**Consultation Response from Emma Mills
KC Landscape**

Application No:	2021/91871
Proposed Development:	Erection of residential development including access and associated infrastructure
Location:	Land adj, High Street and Challenge Way, Hanging Heaton, Batley
Applicant/Agent:	C+W Architects
Planning Officer	Nick Hirst
Date Responded:	18.06.21
Responding Officer:	EM
Responding Ref:	KK49

DRAINAGE APPRAISAL LAYOUT

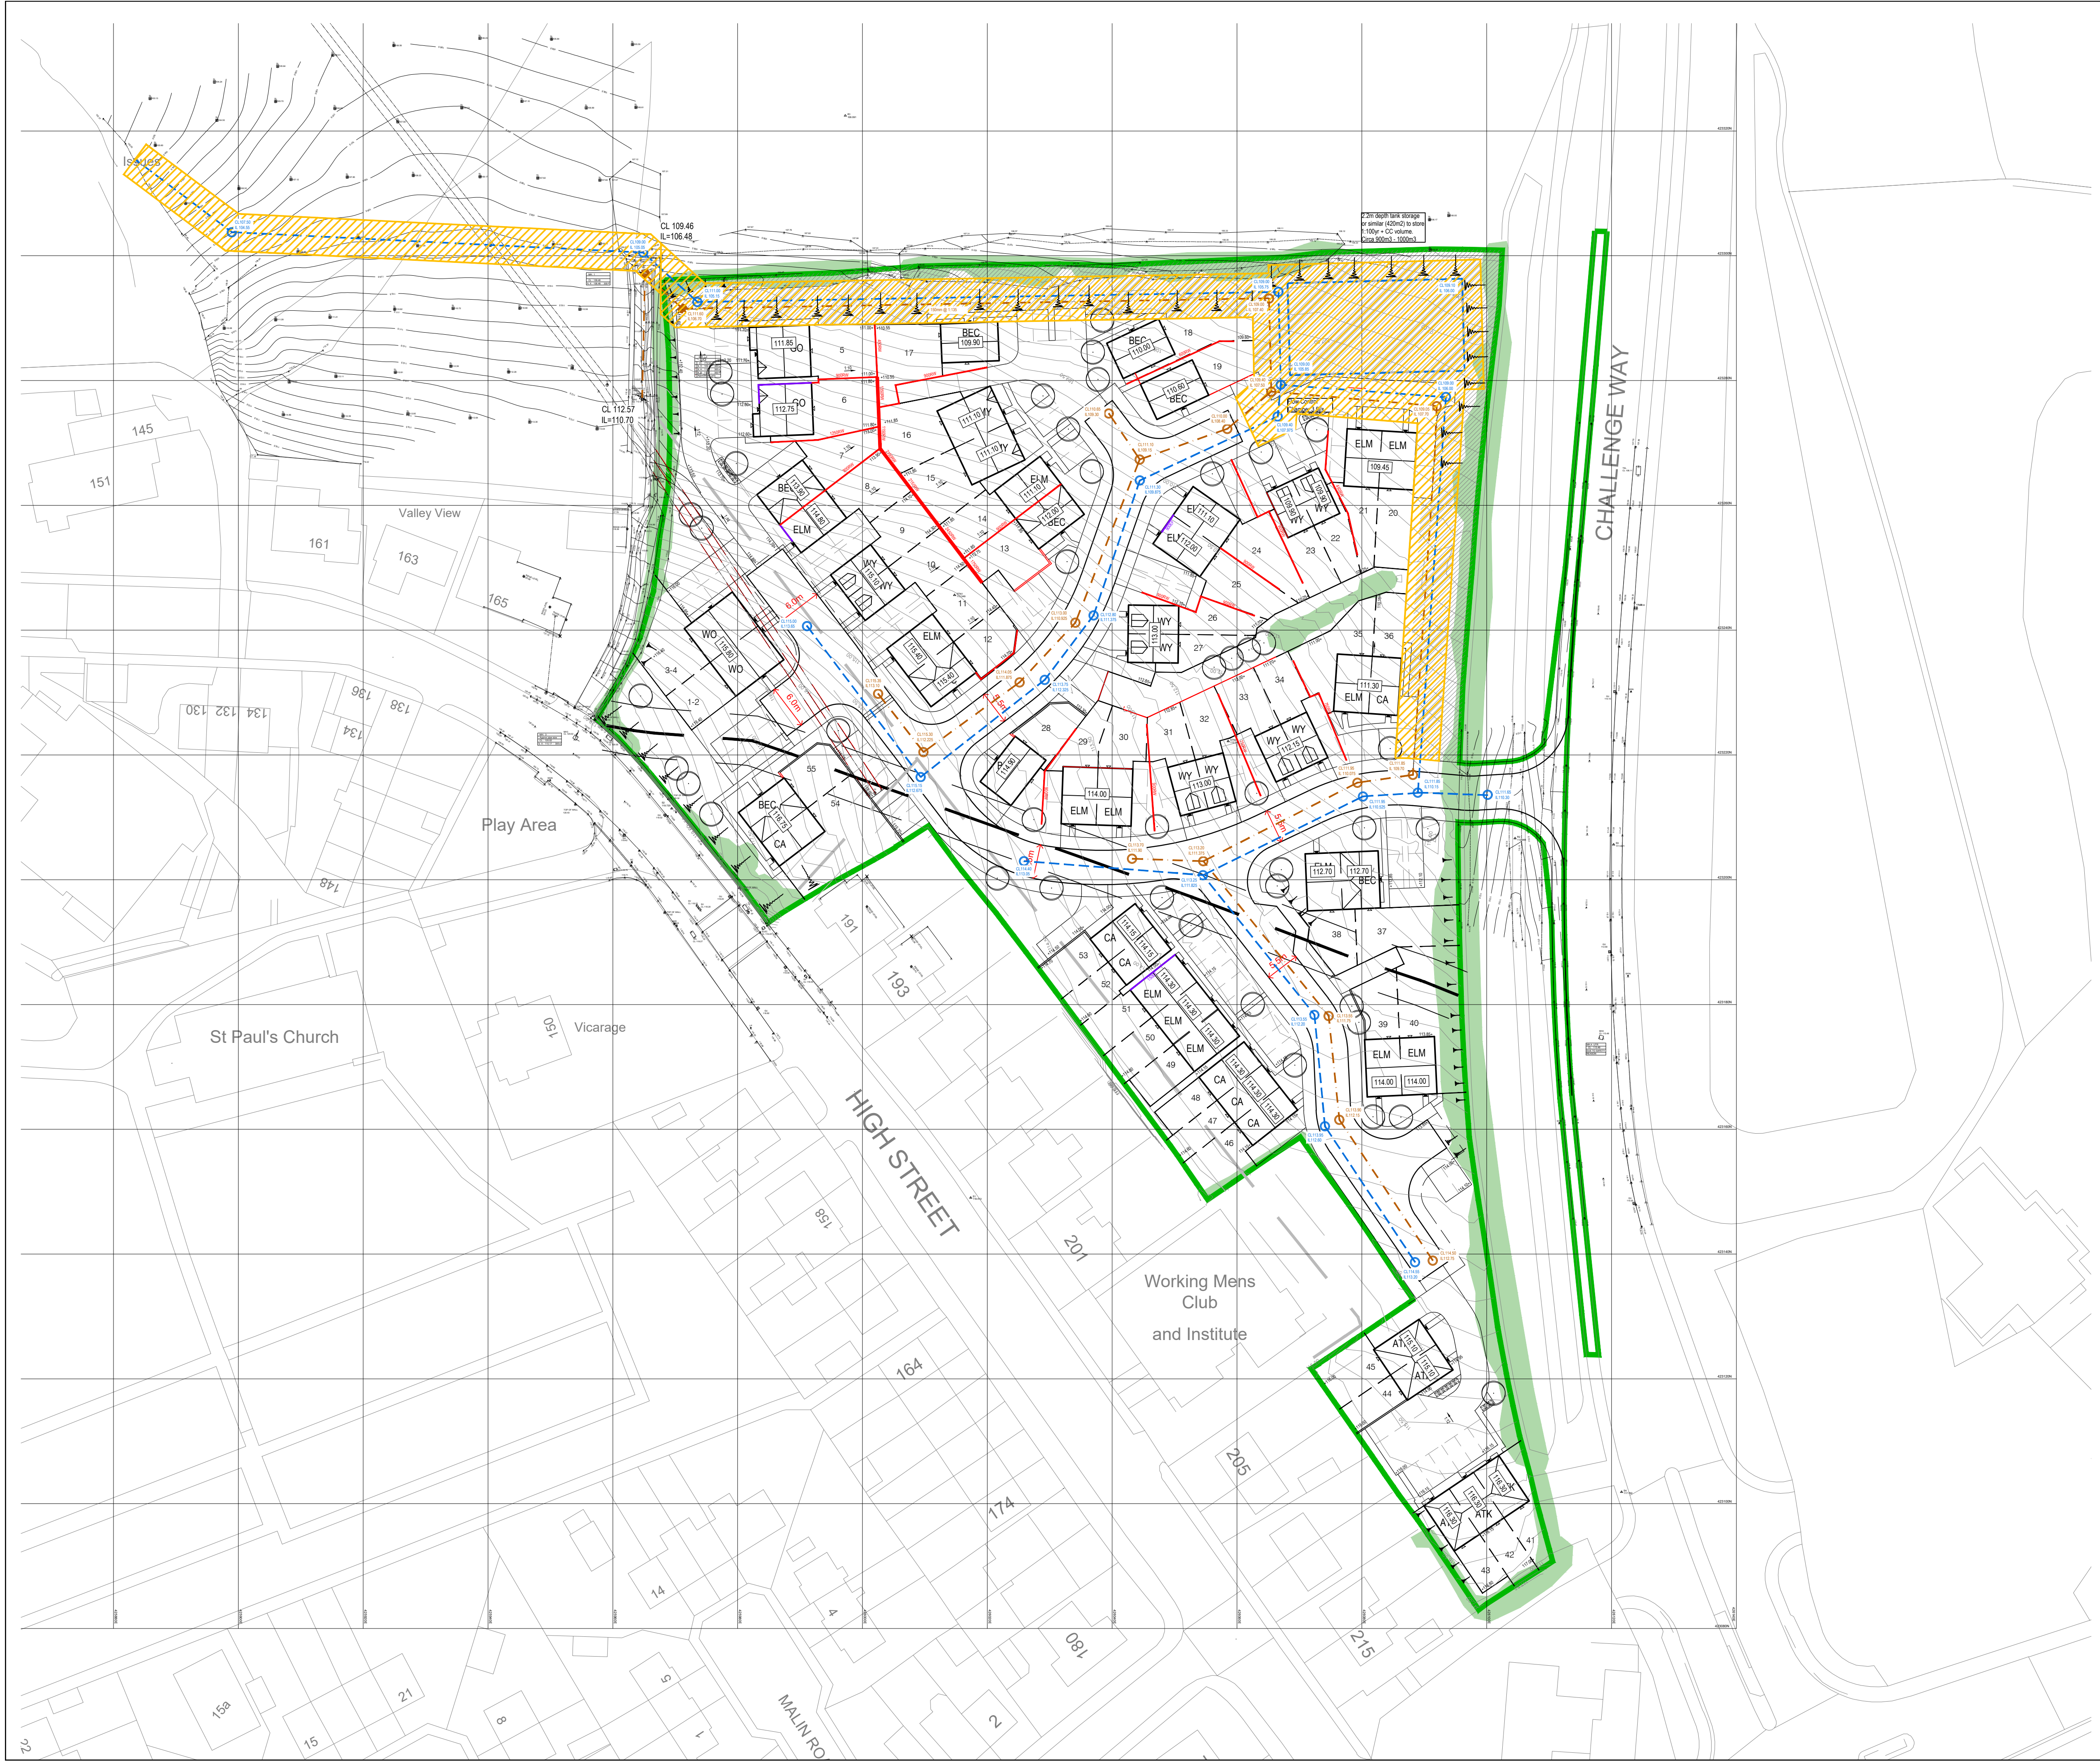
Has an Integrated SuDS scheme been considered to compliment the attenuation area? Rain gardens etc?

Landscape – No objections subject to early submission of detailed landscape information and the above matters addressed – particularly how the POS will be accessed by the residents and community without having to cross a private drive, and the landscape buffer planting along the northern boundary. Also what planting can be incorporated in the pos with the full area being the attenuation?

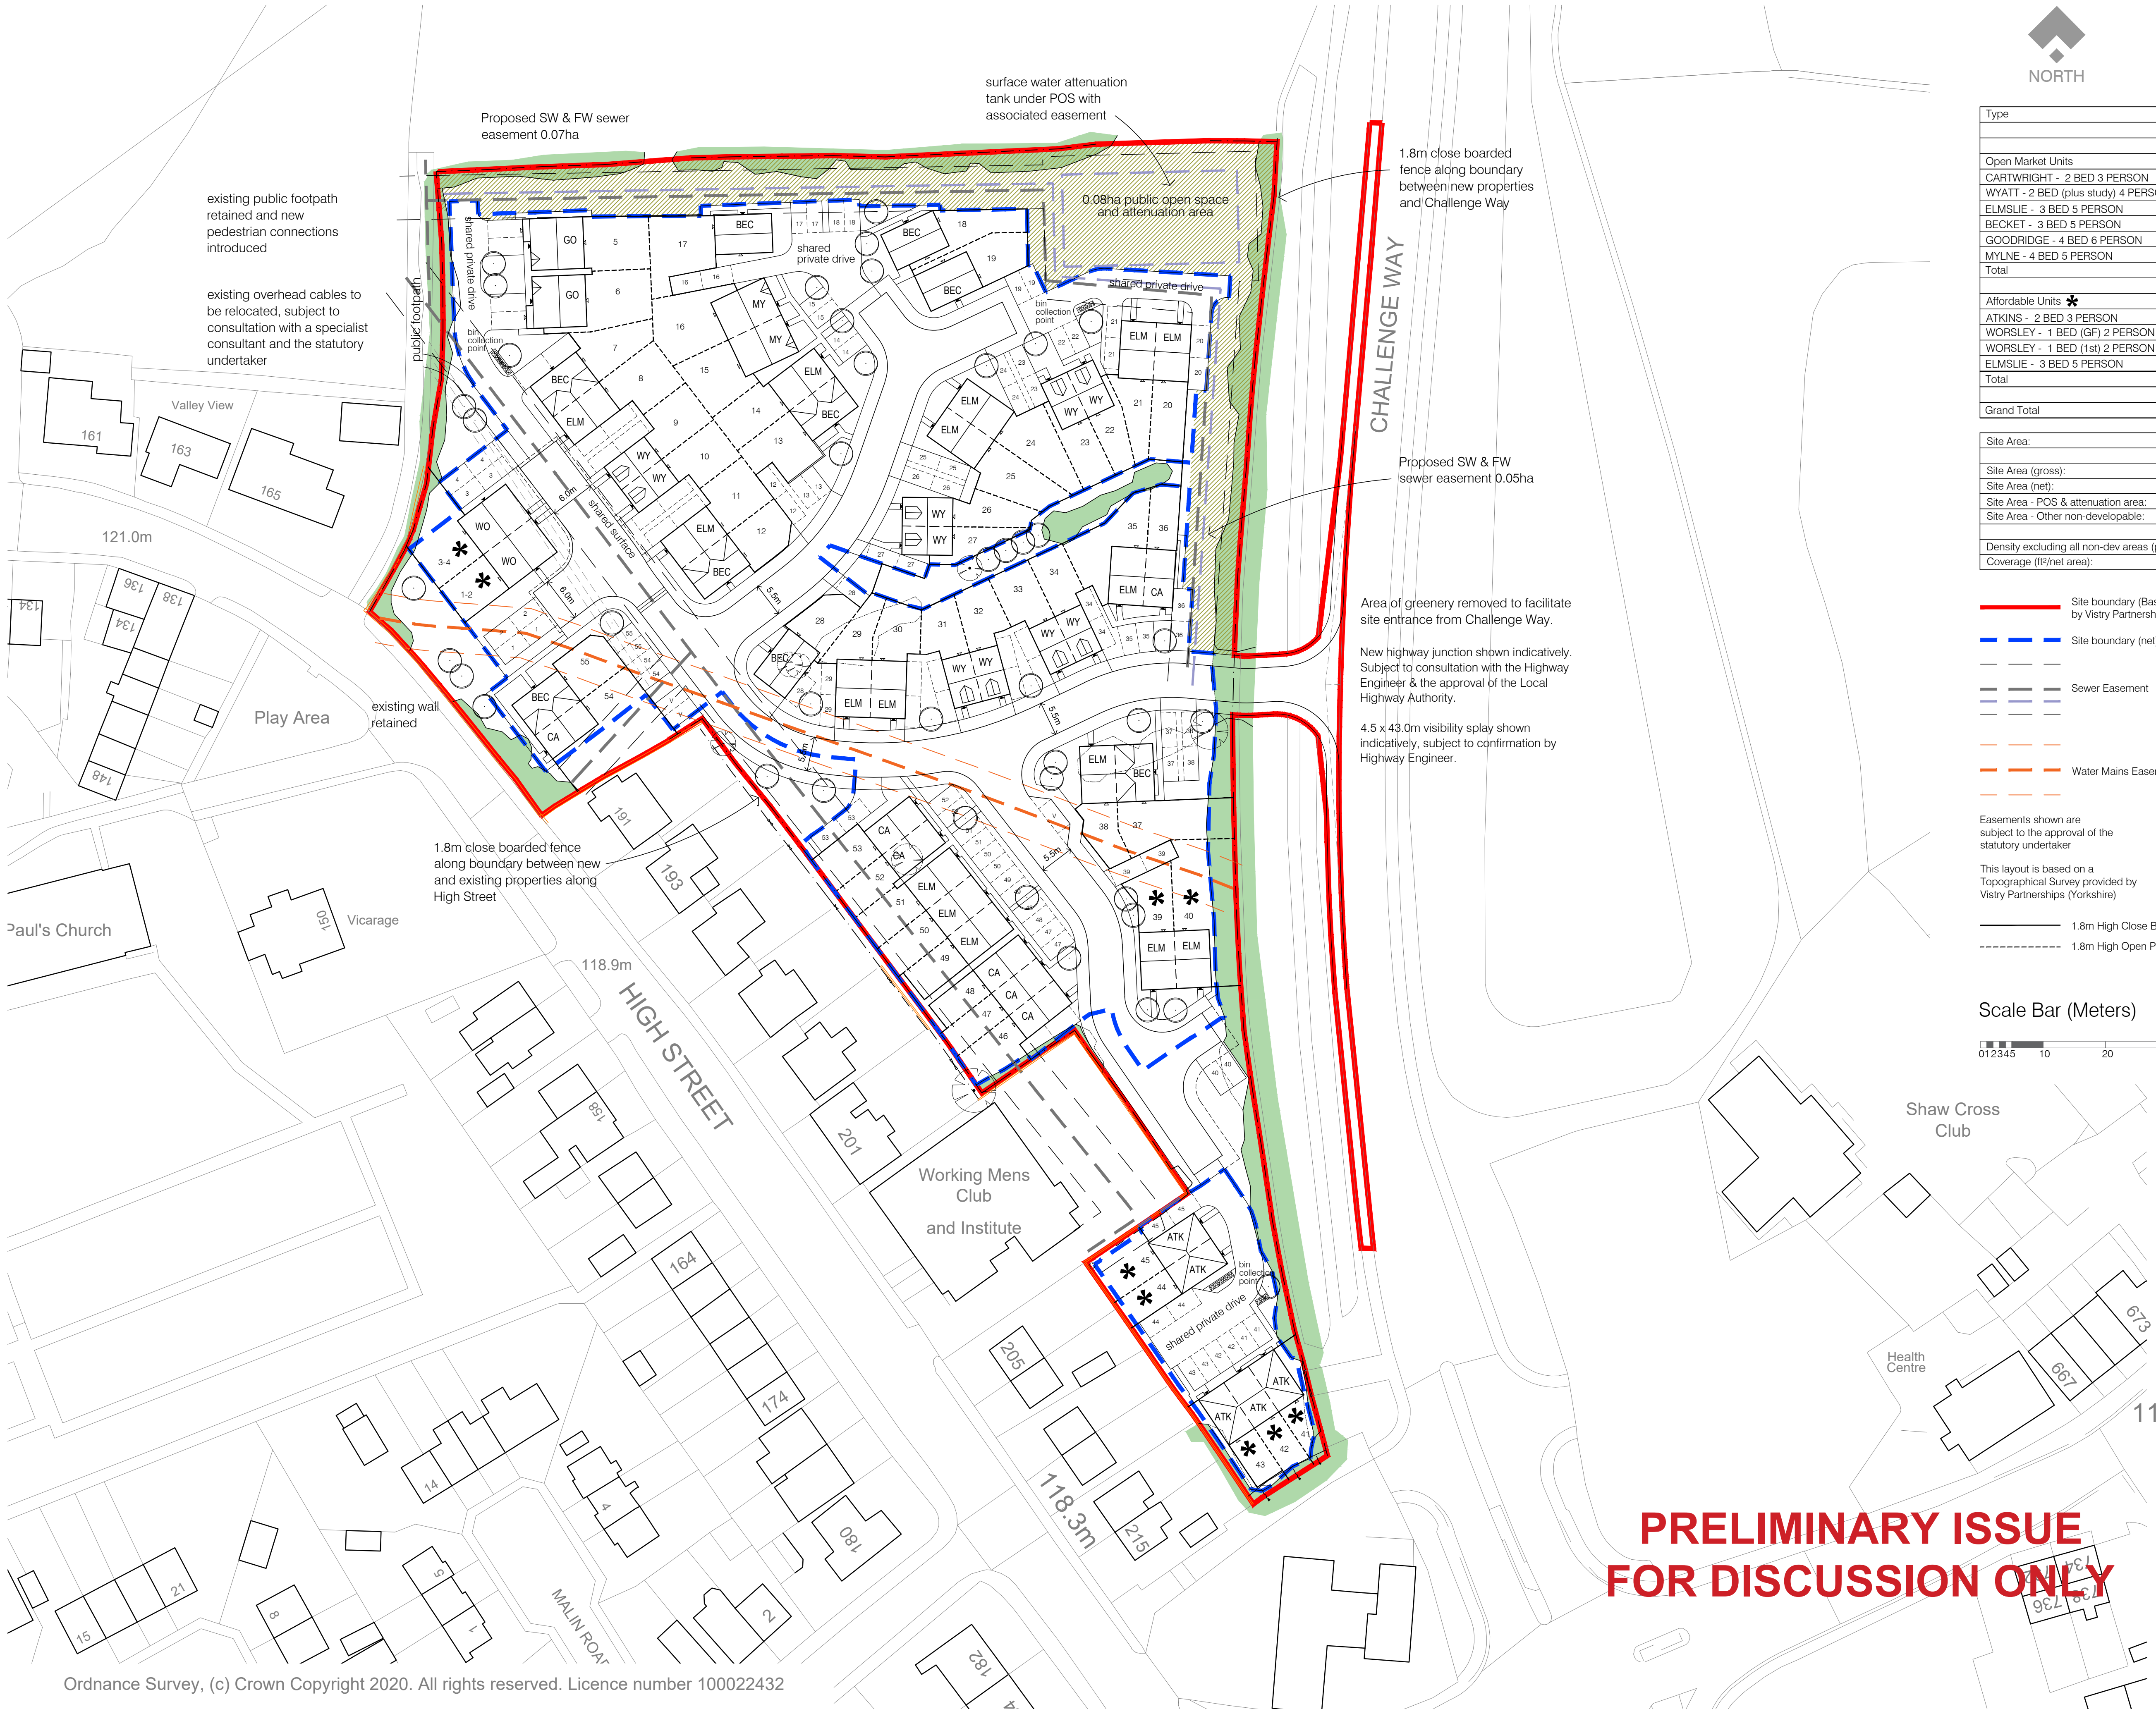
Setting – landscape buffer required to northern boundary. Appears to be an easement so full landscape details will be required.

Greenstreets® - refer to points 2 and 3 below. The proposed street tree planting should meet the requirements in the Highways design guide [highway-design-guide-spd](#), paragraph 4.11 Street Trees, the Key design Driver states there must be a valid and robust reason why an appropriate level of tree planting does not form part of the design. There are more opportunities for trees along the highway in the design.

Concerns about location of pos and strip along easement – lack of natural surveillance and defensible boundaries for the residents backing onto the northern easement – clarification required as to landscape treatment in this area.

Access to and around the POS a concern – unless it is not accessible for use by the residents? What greenspace typologies is it, what is the landscape concept behind the design of this public open space?

How is the new estate road layout connecting with the POS on site, the PROW and surrounding community? **A linking surfaced footpath network should be considered rather than access across a private drive.**
